CITY OF ALBUQUERQUE

June 21, 2018

**RE: St Joseph on the Rio Grande Church
5901 St Joseph Dr NW
Conceptual Grading and Drainage Plan
Engineer's Stamp Date: 6/12/18
Hydrology File: G11D014A**

PROPOSED BASIN MAP

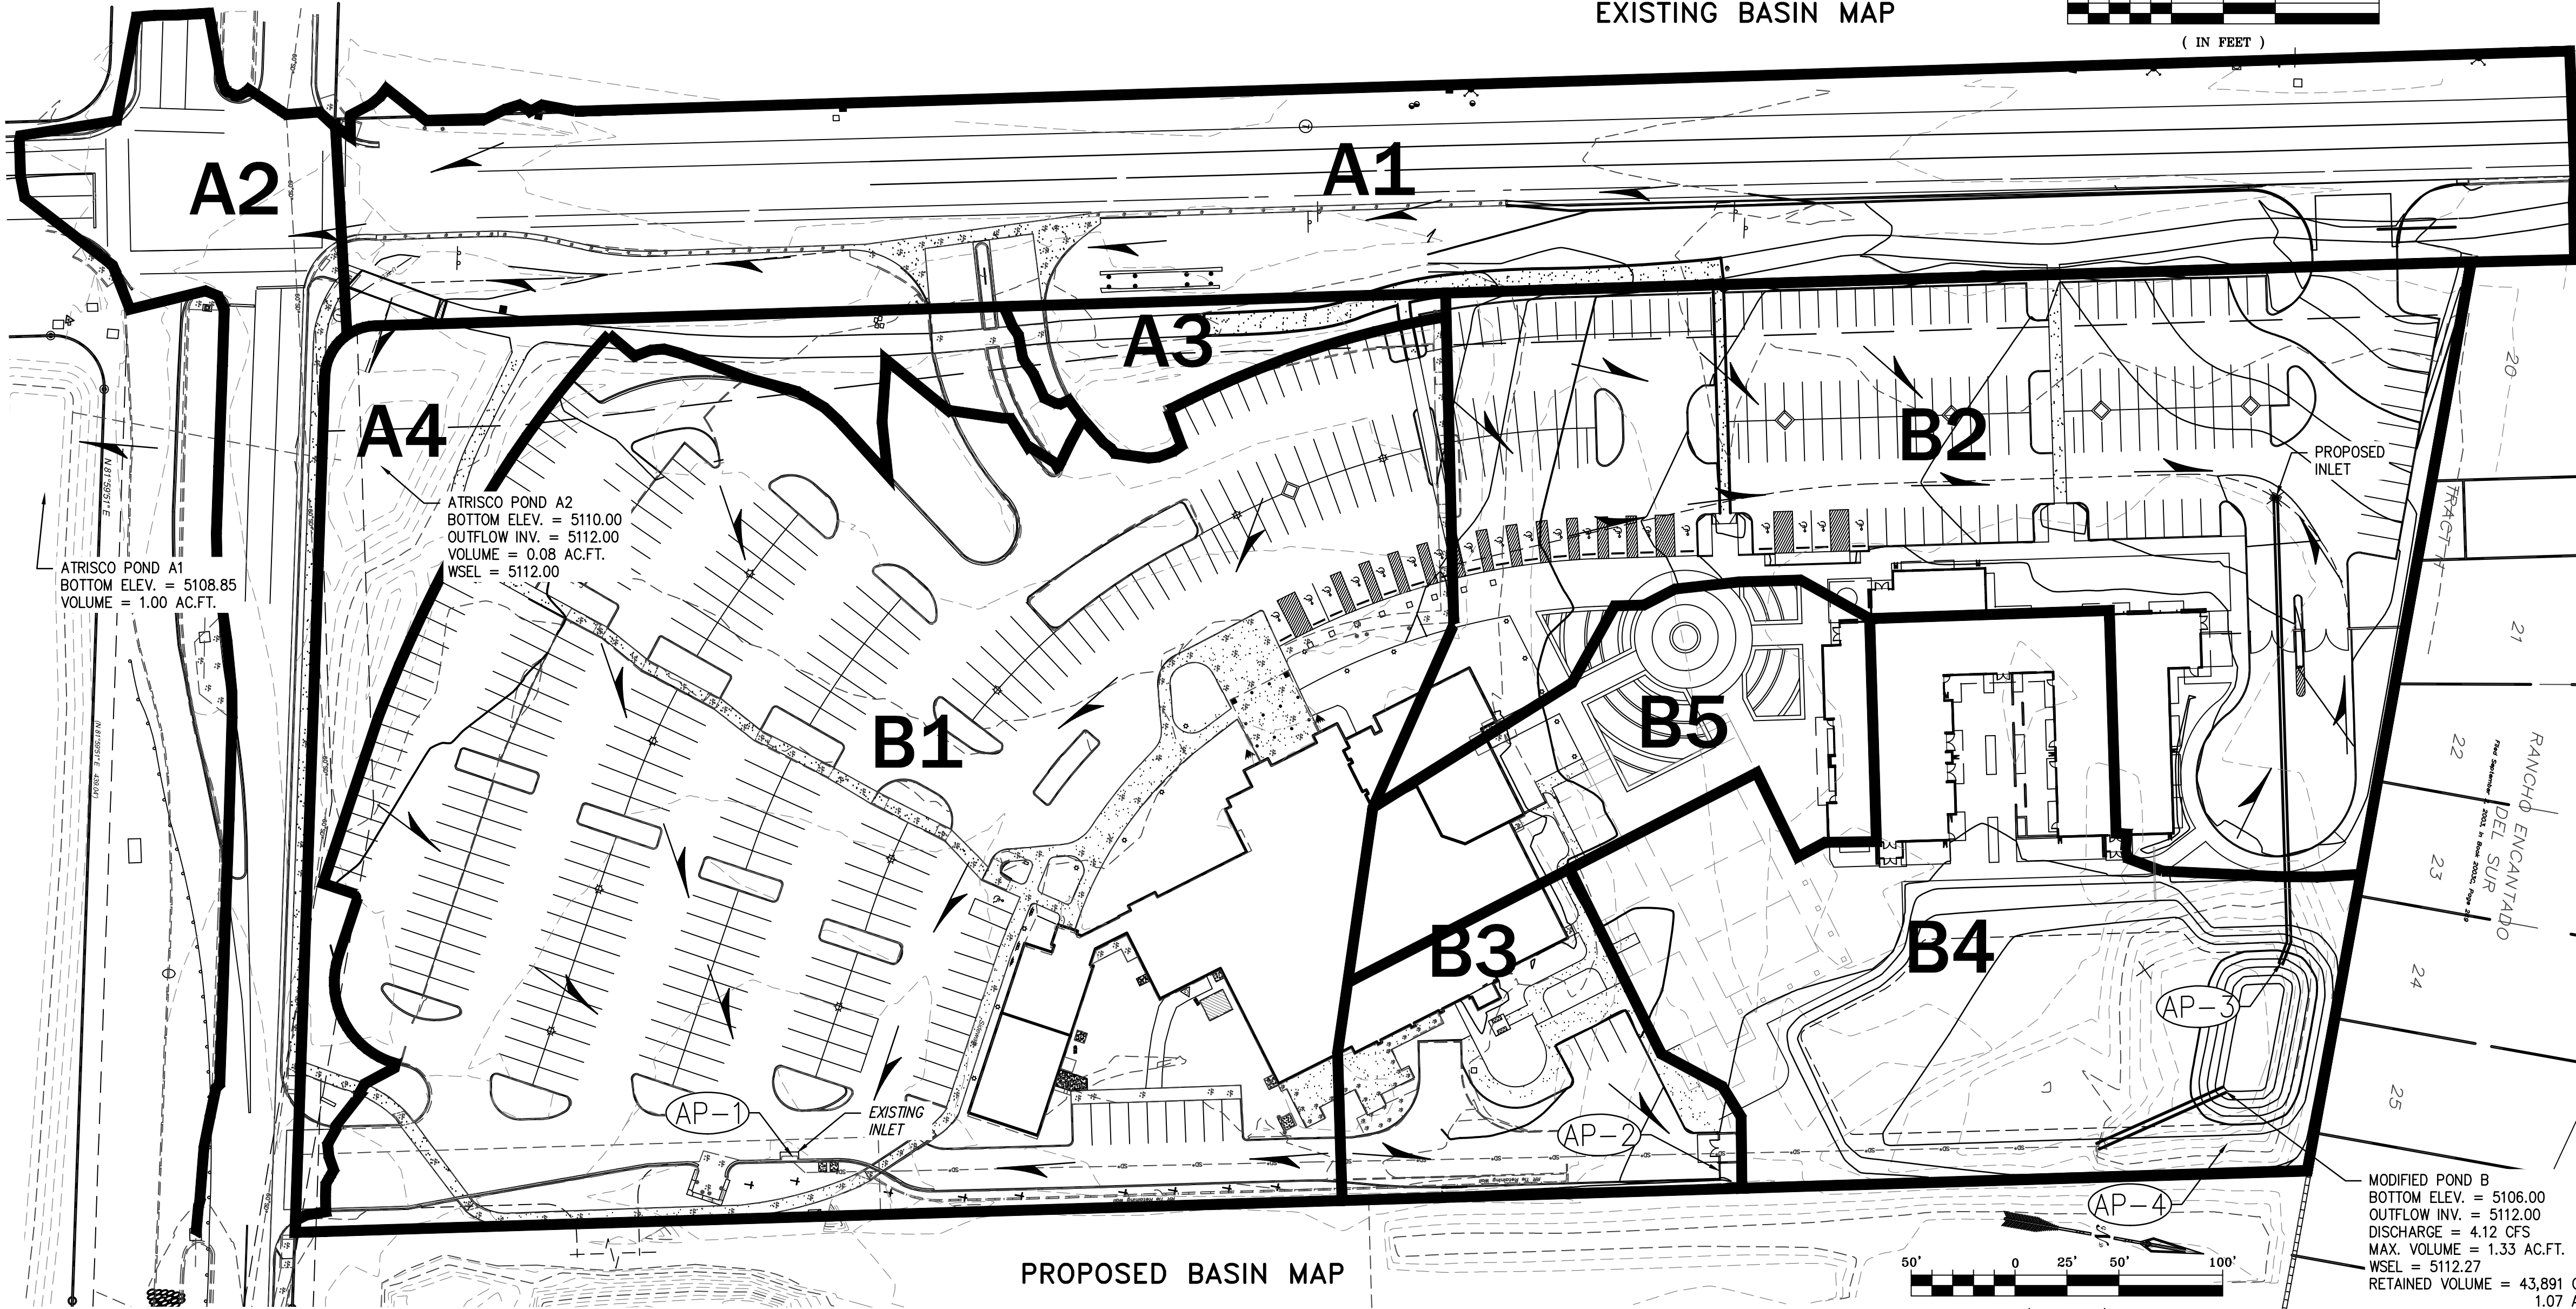
1. The sidewalk culverts will need to call-out std dwg 2236 and provide the culvert width; the diamond plates will need to be extended 1' past edge of sidewalk to avoid a drop-off. Because this is work in the ROW, no adjustments to the private grading plan are needed, but the work order plans will need to show these corrections.

- Madeline Carruthers (mtafoya@cabq.gov, 924-3997) regarding the routing and recording process.
6. This project requires an ESC Plan, submitted to the Stormwater Quality Engineer (Curtis Cherne PE, ccherne@cabq.gov or 924-3420).
 7. Provide invert-out elevation for both outfalls into the private pond.
 8. Provide an emergency spillways or 2x capacity for the private storm drain; this is applicable when the inlets are in a sump conditions. Provide supporting calculations for the chosen options.
 9. Additional comments can reasonably be expected at Building Permit, based on the outcome of the above remarks and level of detail shown on plans.
 10. The resubmittal fee for this drainage submittal is: \$150.
